From: ENVU Biodiversity and Land Use
Sent: 18 November 2025 10:53
To: Planning ContactCentre
Subject: doc 2025/92886 at location adj, 13, Queen Street, Mirfield, WF14 8AH

I understand that this is to review the discharge of conditions 5 and 6 of 2023/91383:

Site - Conditions

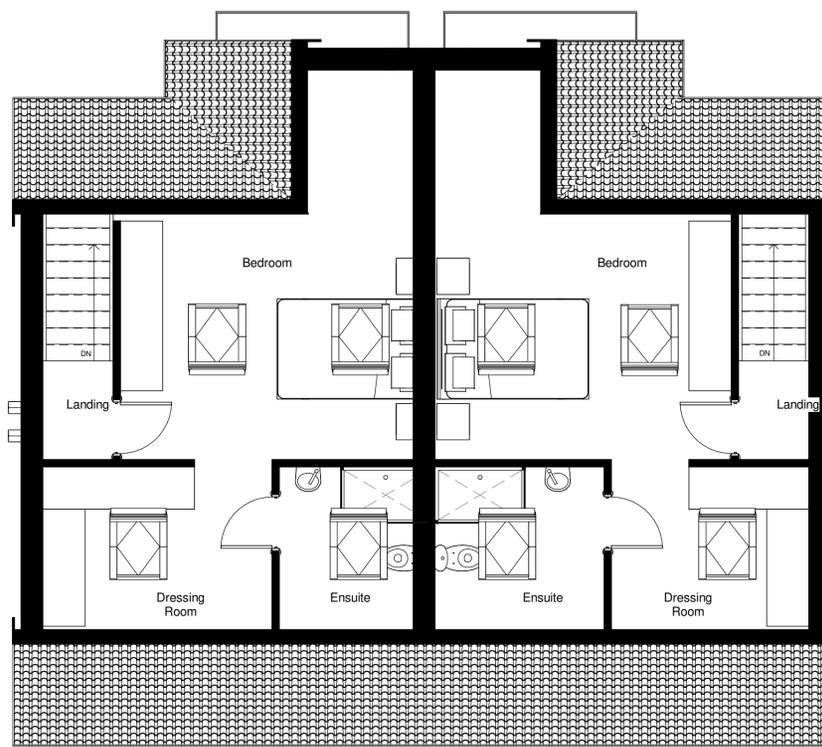
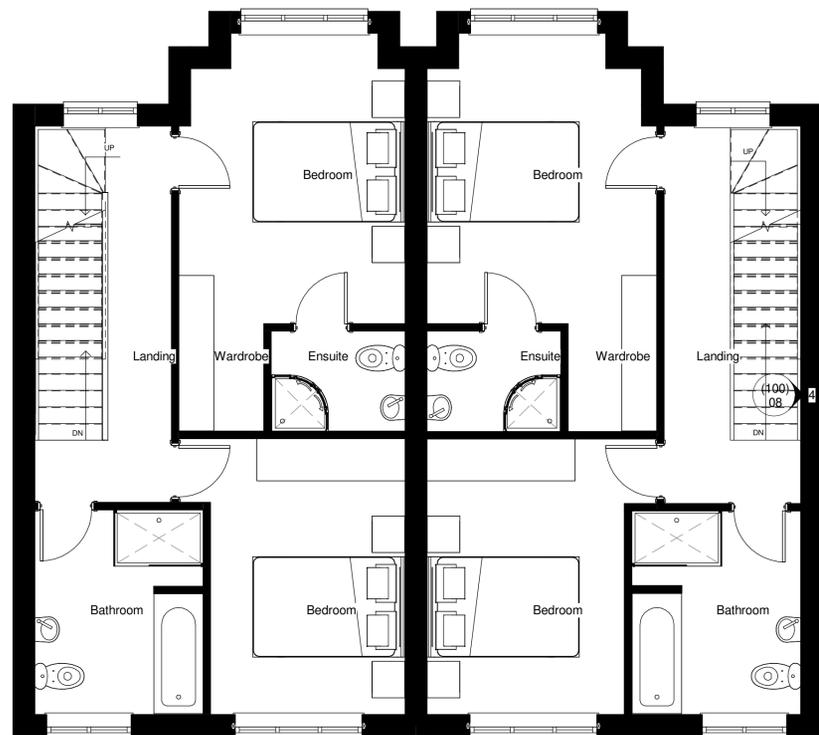
Condition 6 – Bat and bird boxes

The site plans from Acumen have been reviewed. These are acceptable and in line with the requirements of the condition.

Condition 6 is met.

Site - Lighting Design - Conditions

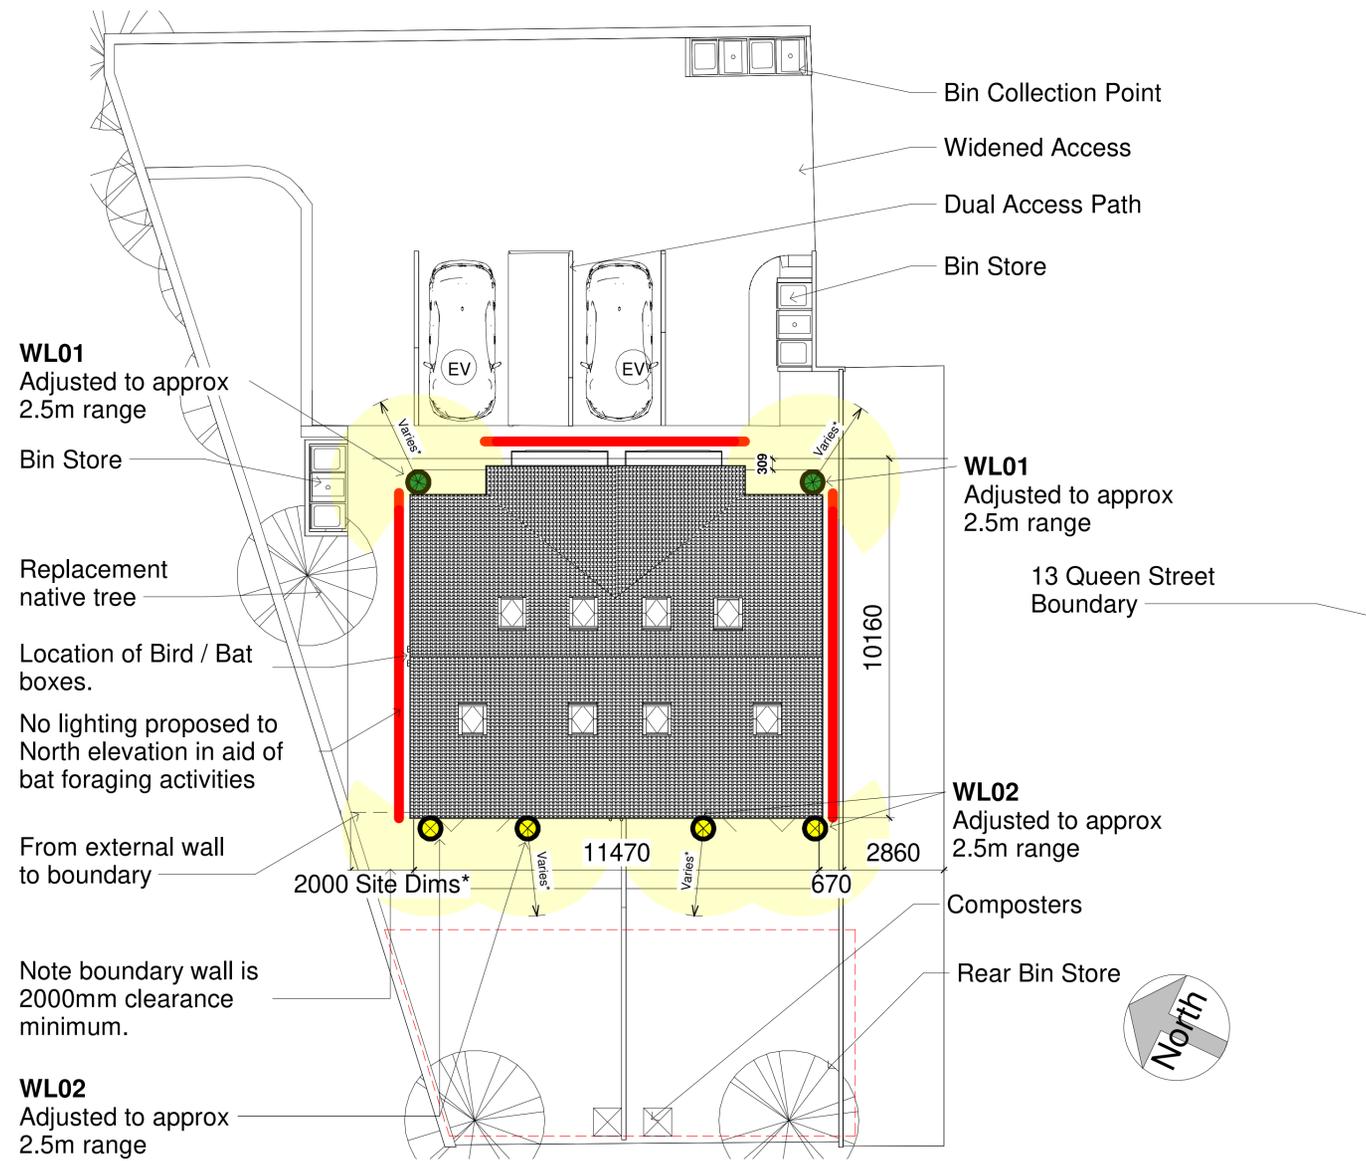
Condition 5 – lighting

The lighting designs from Acumen have been reviewed. These are acceptable and in line with the requirements of the condition.

Condition 5 is met.
